From: [Bill Booker](#)
To: [Price, Robert](#)
Cc: [Simon Cope \(simon.cope@eurogarages.com\)](#); [Tim Hancock](#); [Wilson, Andy](#); [Betts, Simon](#); [A38 Derby Junctions](#)
Subject: RE: Statement of Common Ground
Date: 02 April 2020 11:56:07
Attachments: [image004.png](#)
[A38 Derby Junctions Scheme.msa](#)

I have been able to take instruction from EGL on this matter and have been instructed that the SoCG remains unagreed and therefore we are unable to sign the document. This is given the level of issues that are outstanding in respect of the proposed site access alterations from the A52.

From: [Bill Booker](#)
To: [Wilson, Andy](#)
Cc: [Simon Cope \(simon.cope@eurogarages.com\)](mailto:simon.cope@eurogarages.com); [Tim Hancock](#);
["Christopher.Archbold@highwaysengland.co.uk"](mailto:Christopher.Archbold@highwaysengland.co.uk)
Subject: A38 Derby Junctions Scheme

The
 ADL PROPOSED ACCESS AND EGRESS
 OFF HIGHWAYS ENGLAND SLIP LANE

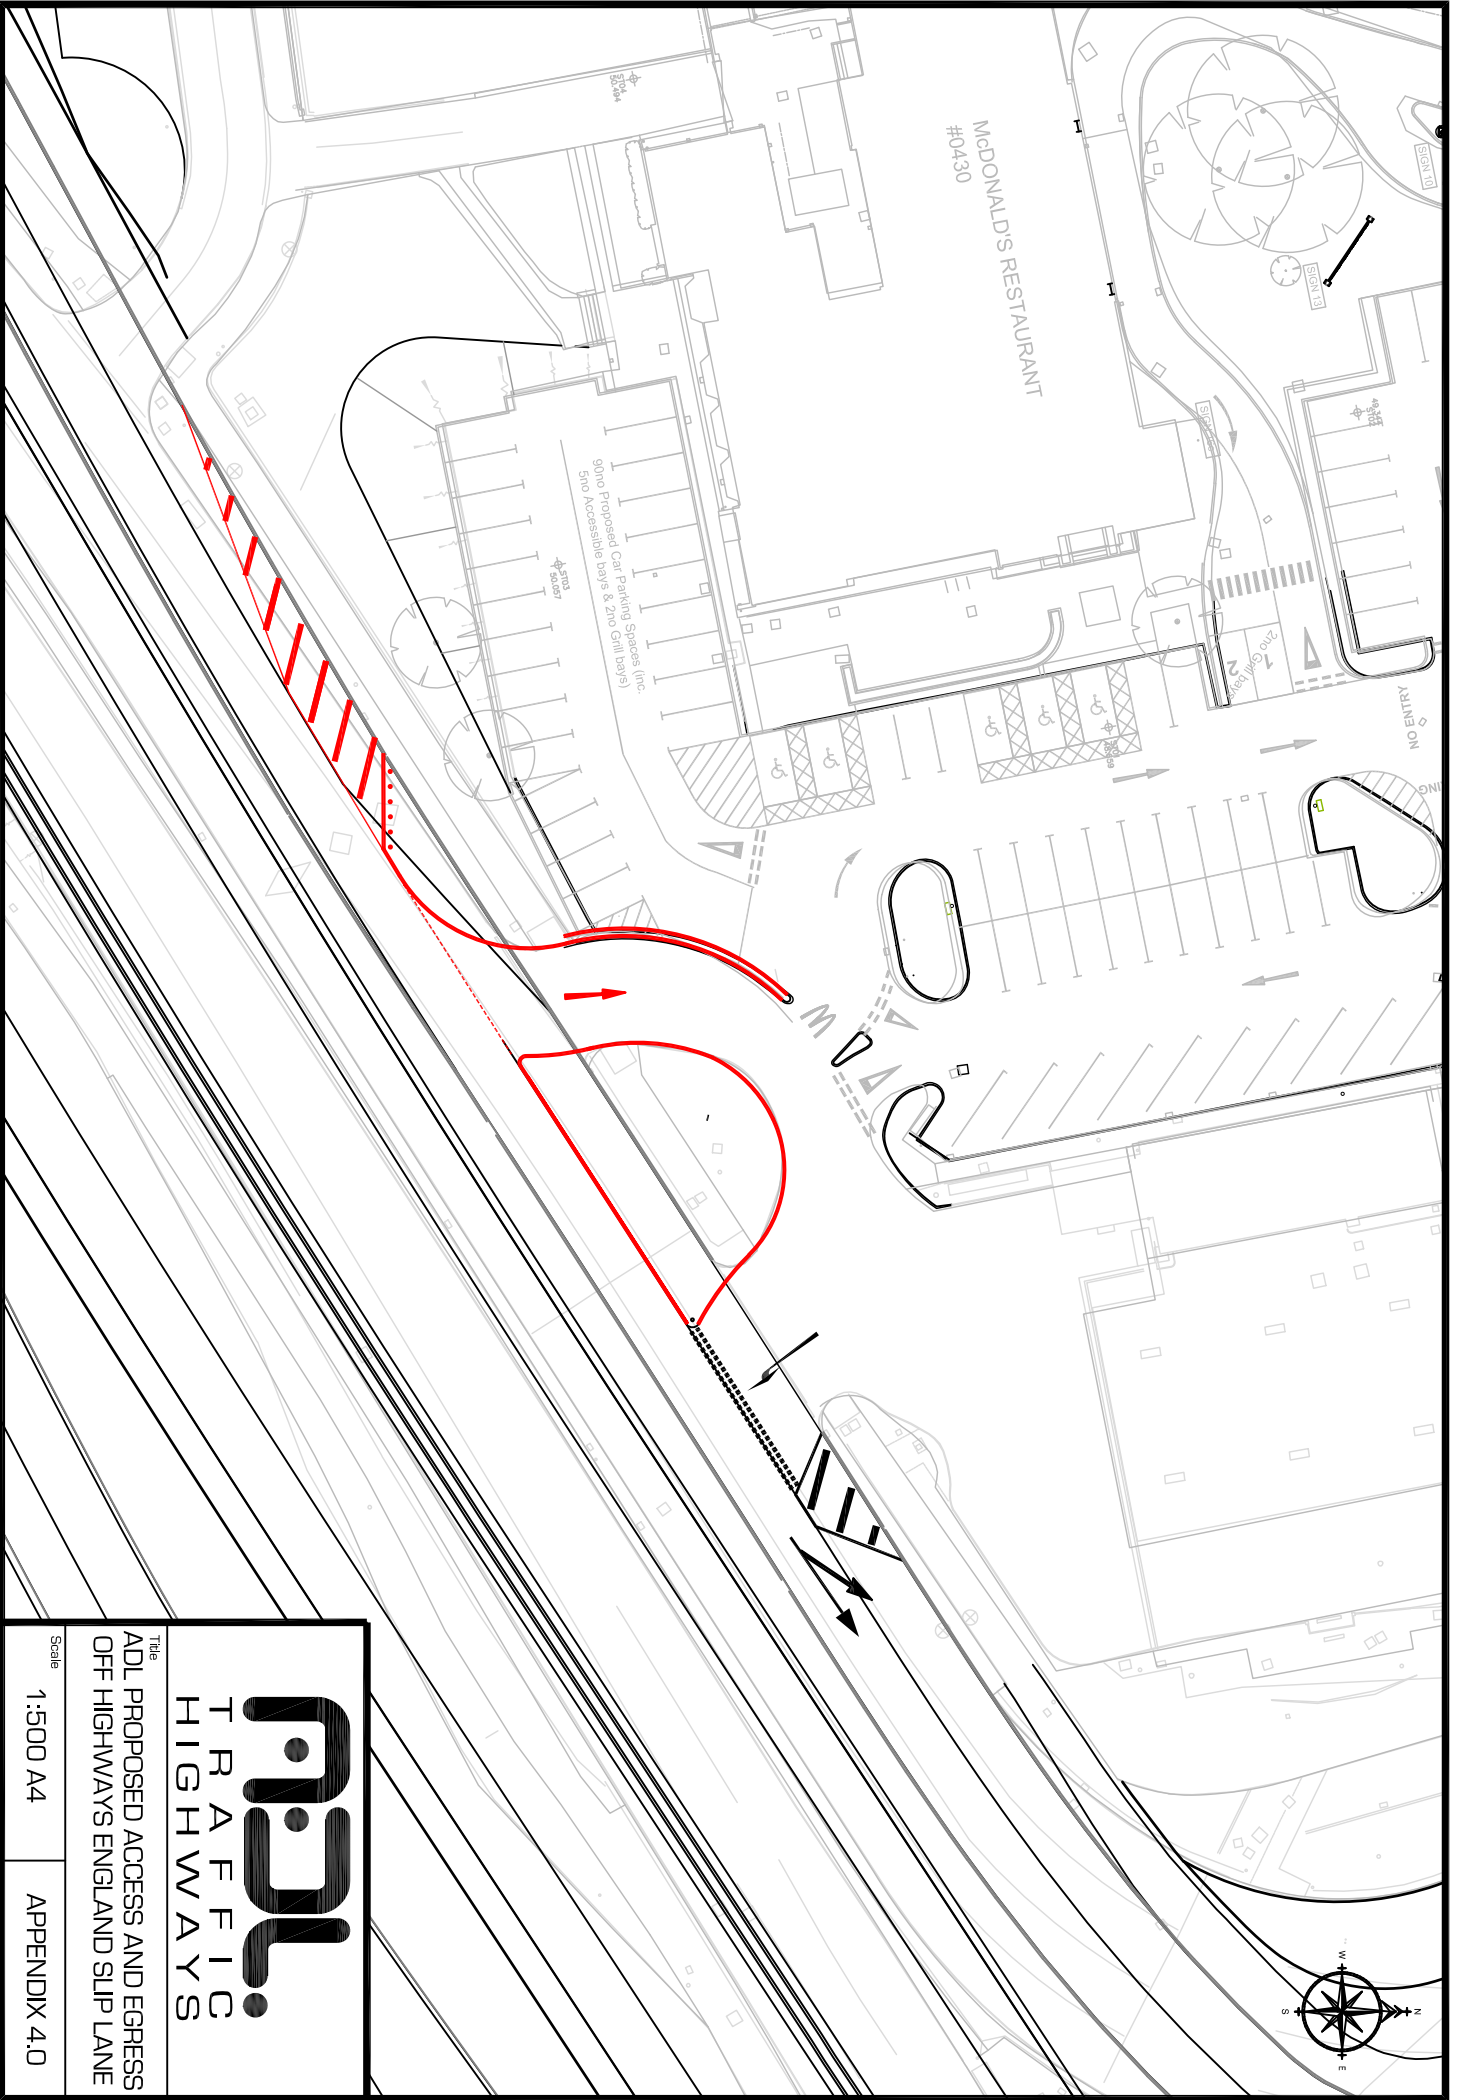
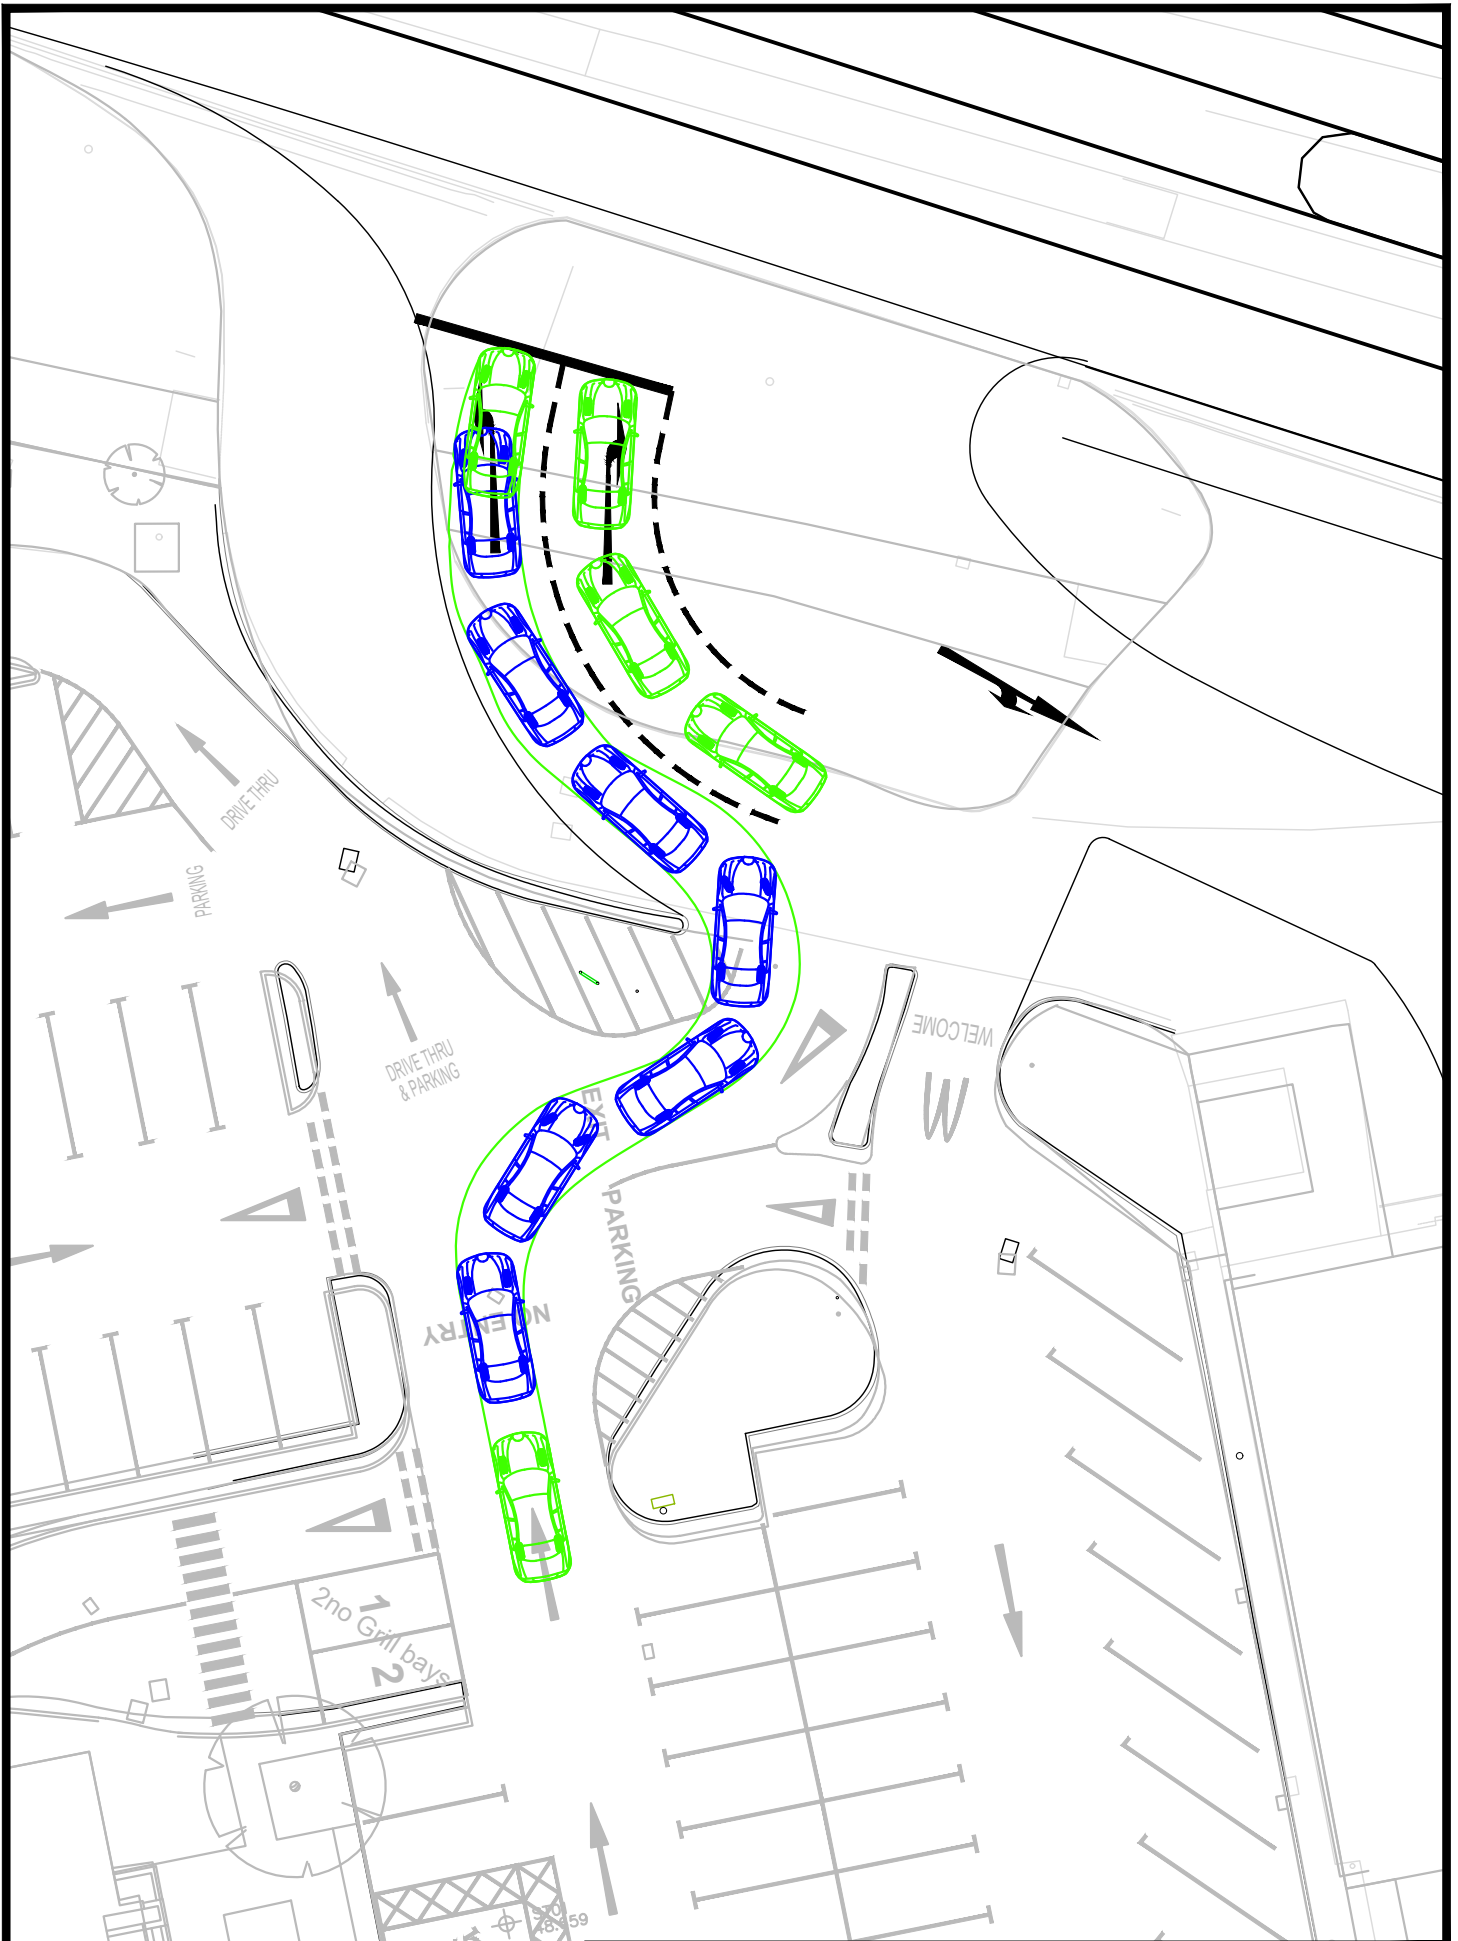
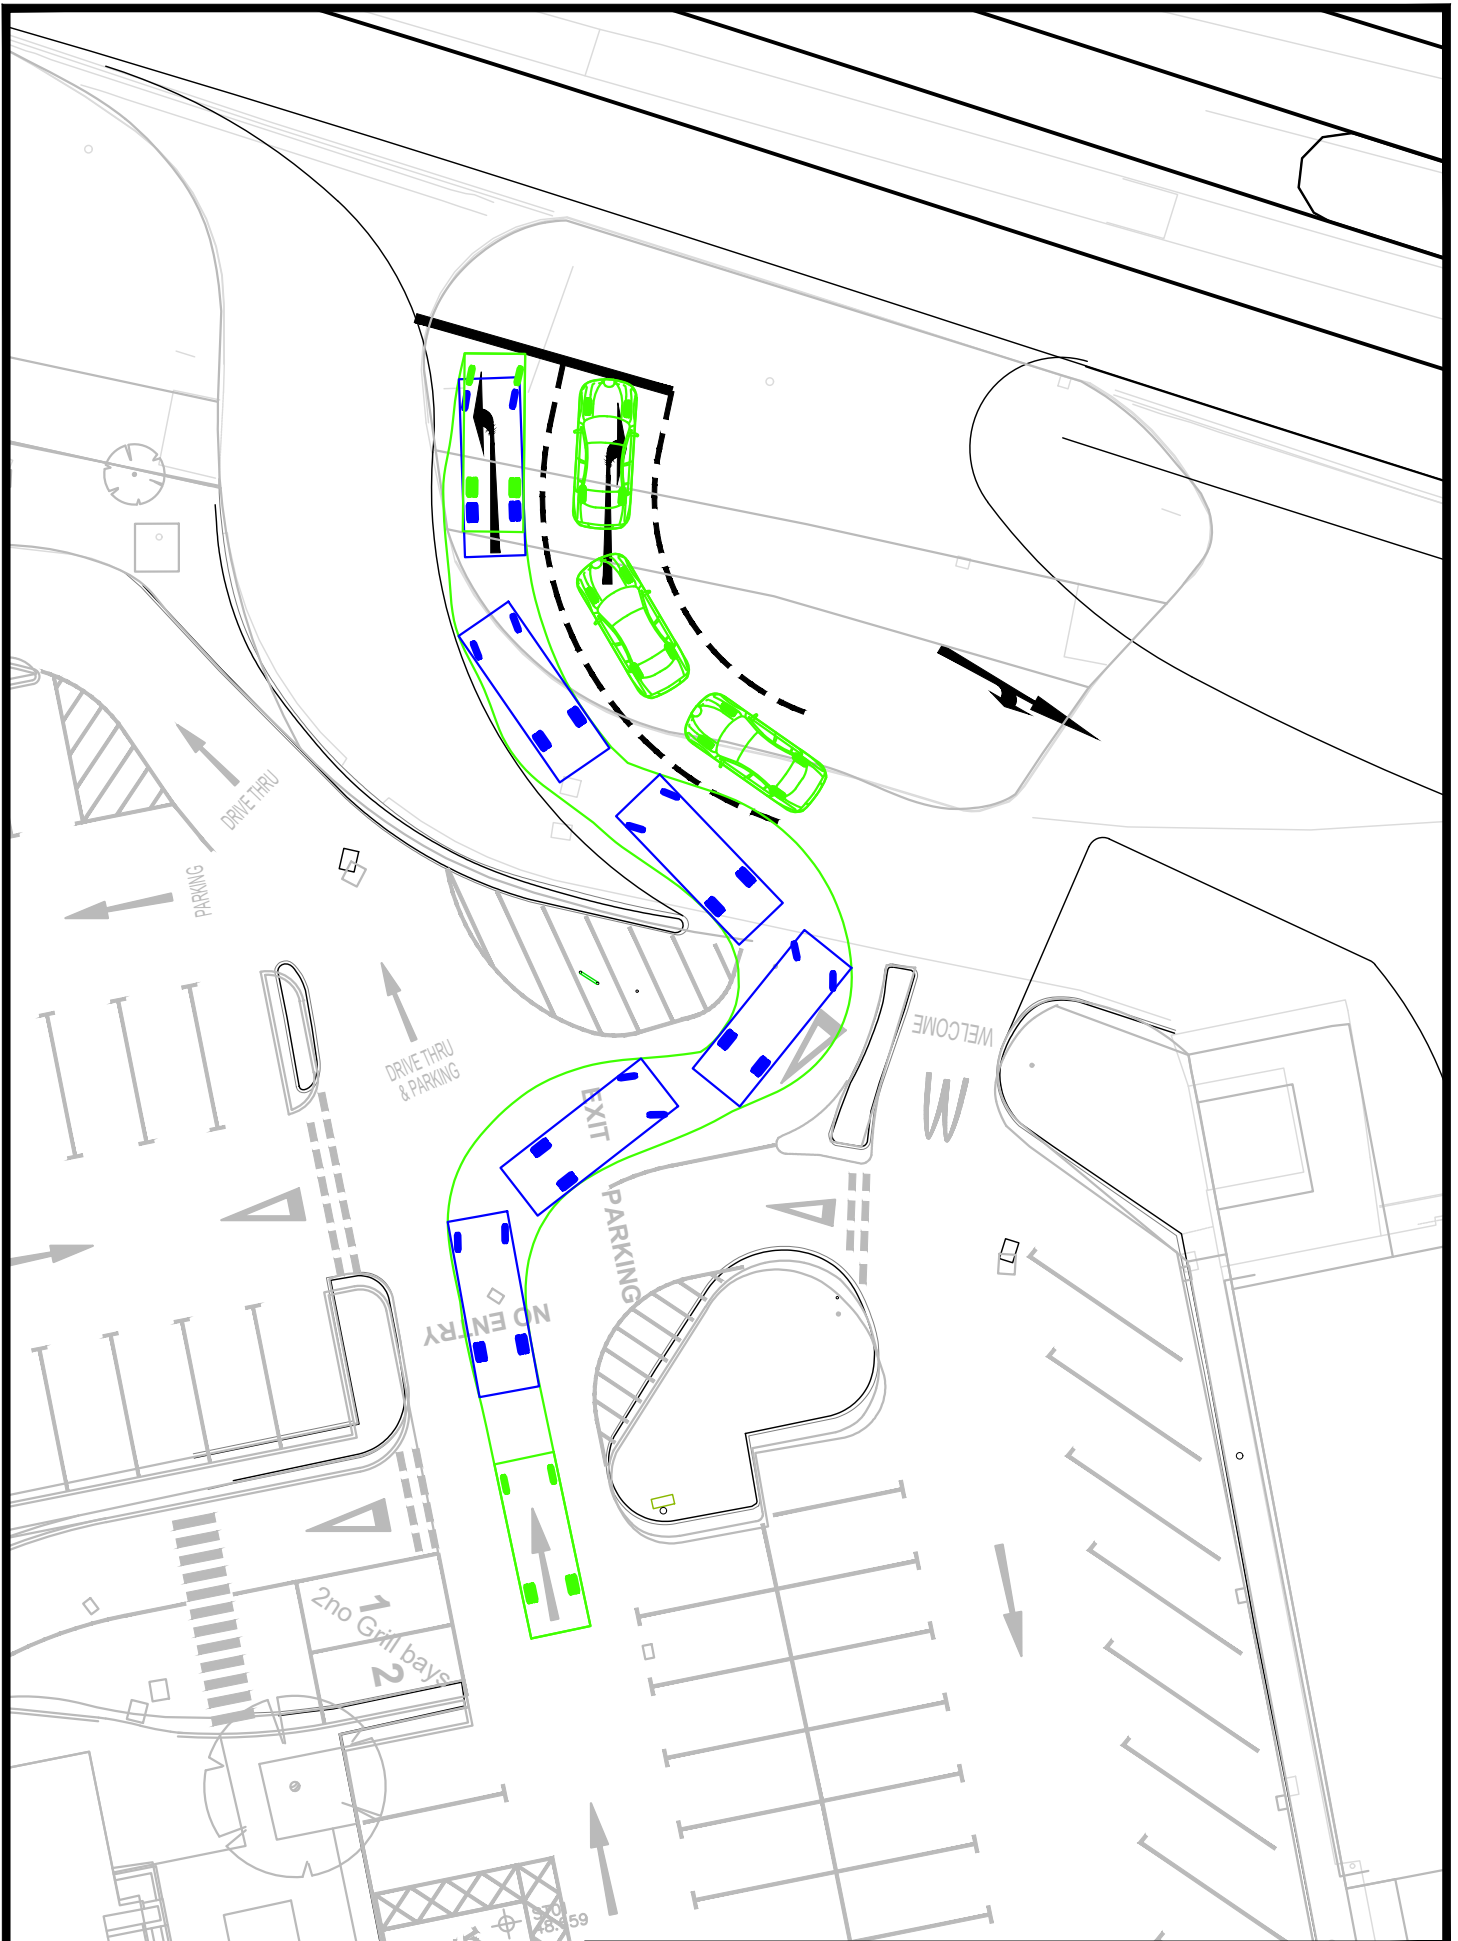
- 5) The proposed A38 ingress alterations does impinge upon the existing right of way for EGL from the A38 into their site.
- 6) The alteration to the A38 ingress requires McDonalds deliveries to use the A52 access and alters the pattern of movement within the site. The swept paths demonstrate that the McDonalds delivery vehicle would need to pass onto EGL land where there is no right of way.
